Application number: 2026/91738	
What is the application for?:	Change of use from retail to retail coffee shop and bar with alcohol
Address of the site or building:	6, Station Road, Skelmanthorpe, Huddersfield, HD8 9AU
Postcode:	HD8 8DL

Type of comment: An objection	
Do you wish your comments to be published on the website anonymously?	Yes
6 Station Road, Skelmanthorpe, Huddersfield, HD8 9AU 2026/62/91738/E We have reviewed the additional information recently published on the planning portal, specifically the revised ground floor plan detailing internal alterations. Upon careful examination, we have serious concerns regarding the accuracy of the drawings, as it appears the details may have been materially altered to circumvent relevant planning policy requirements. Accurate, to-scale drawings are a fundamental requirement for any planning application, however, a comparative assessment of the latest plans reveals that the overall building footprint has been significantly altered from the previously submitted plans, with both the width and length of the property reduced by approximately 1.6 metres, and previous dimensions have been omitted. This apparent manipulation seems intended t

BUILDING WORK COMPLETED AND DRAIN
LOCATED NEW DRAIN CONNECTION
= LATEST BAR DESIGN

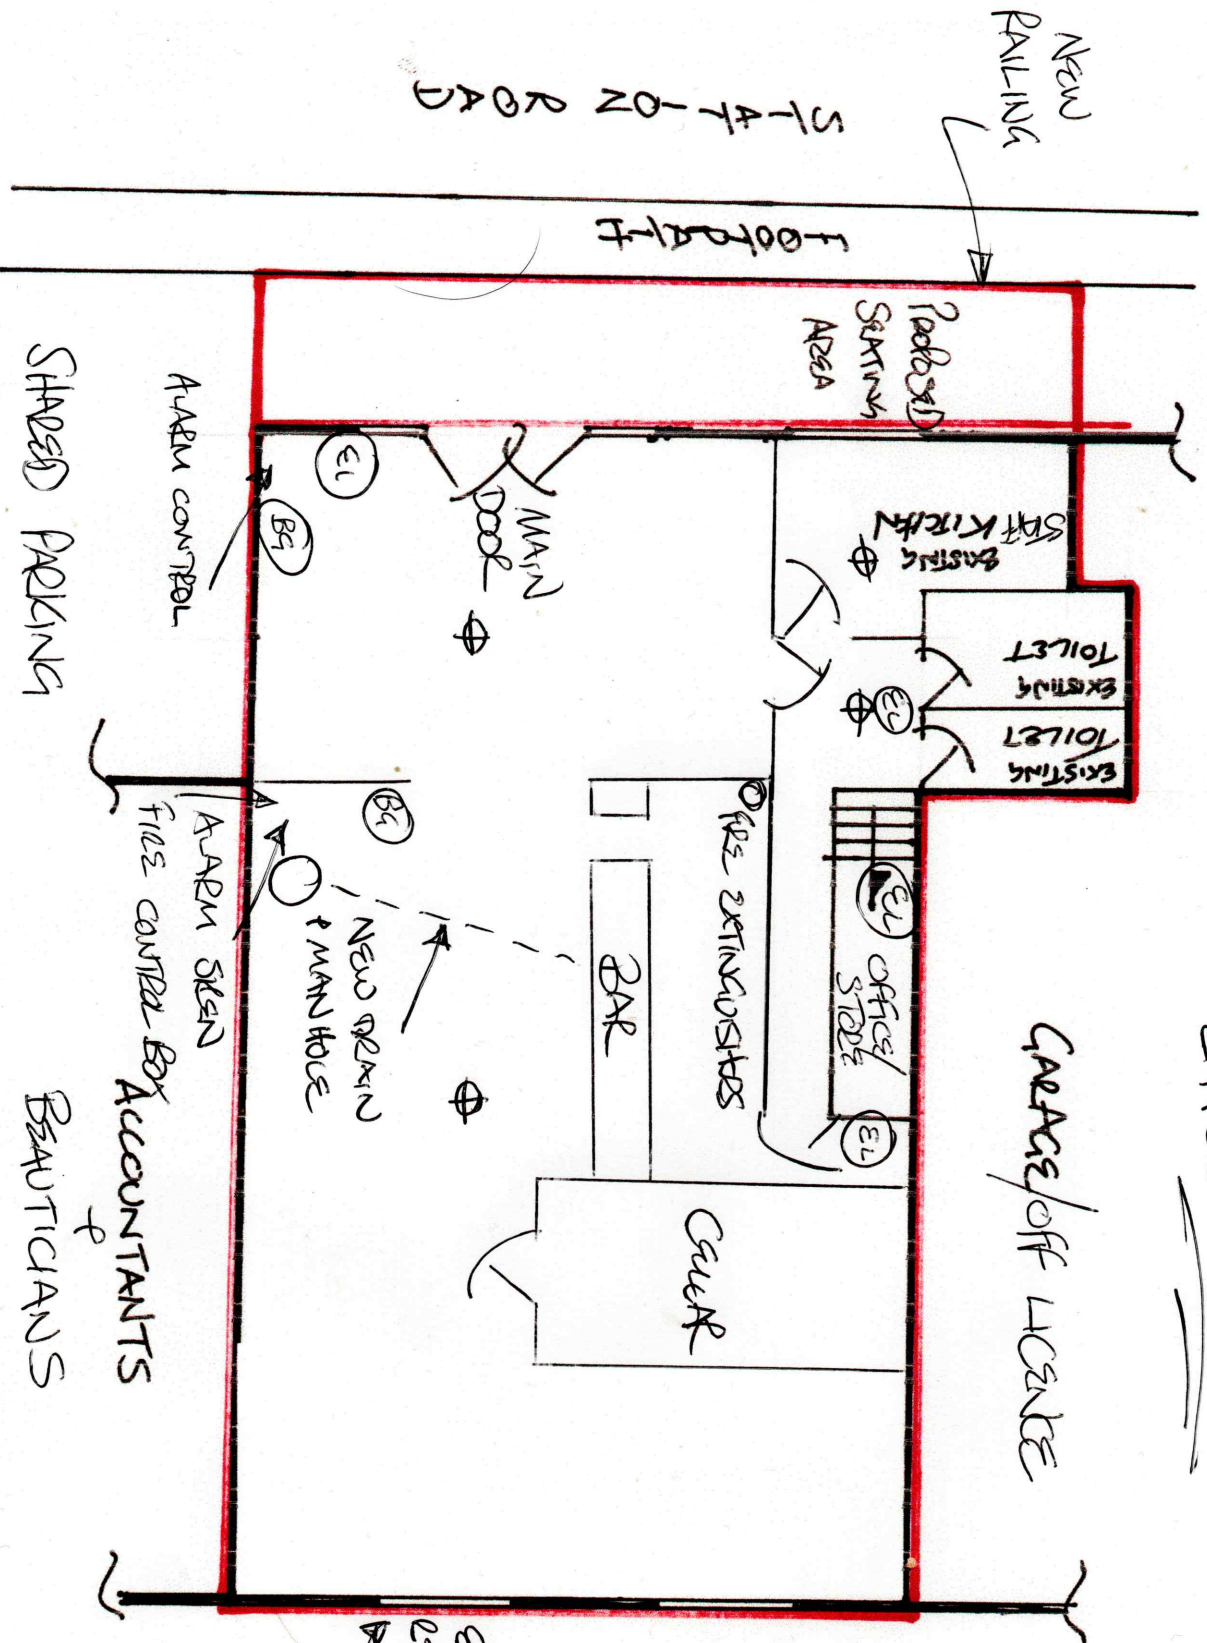
- **Off-Licence Annotation:** The drawings incorrectly reference an off-licence. As the village store is no longer operational, the plans should be updated to reflect the current site conditions.

- **Omission of GA Plans:** Stairs providing access to a first-floor office/store are shown, yet the corresponding General Arrangement (GA) plans have not been provided. The submission of these plans should be a prerequisite for application validation.

- **Rear Egress Window:** The proposed rear egress window is unacceptable, as it would require access over third-party land and is not compliant with current legislation.

- **Kitchen Usage Clarification:** The kitchen is currently labelled as an "existing staff kitchen." Please clarify whether this facility is restricted solely to staff use, or if it will be utilised for the commercial preparation and sale of food on-site. On the planning forms it clearly states, sale of food and drink for consumption on the premises.

- **Internal Drainage Configuration:** A new drain and manhole connection are proposed within the building's interior. Please confirm whether this design is acceptable to Yorkshire Water. Furthermore, this arrangement raises significant environmental health concerns regarding the risk of drains backing up and surcharging into the building. On the planning forms it states that there will be no new connections when clearly there will be.
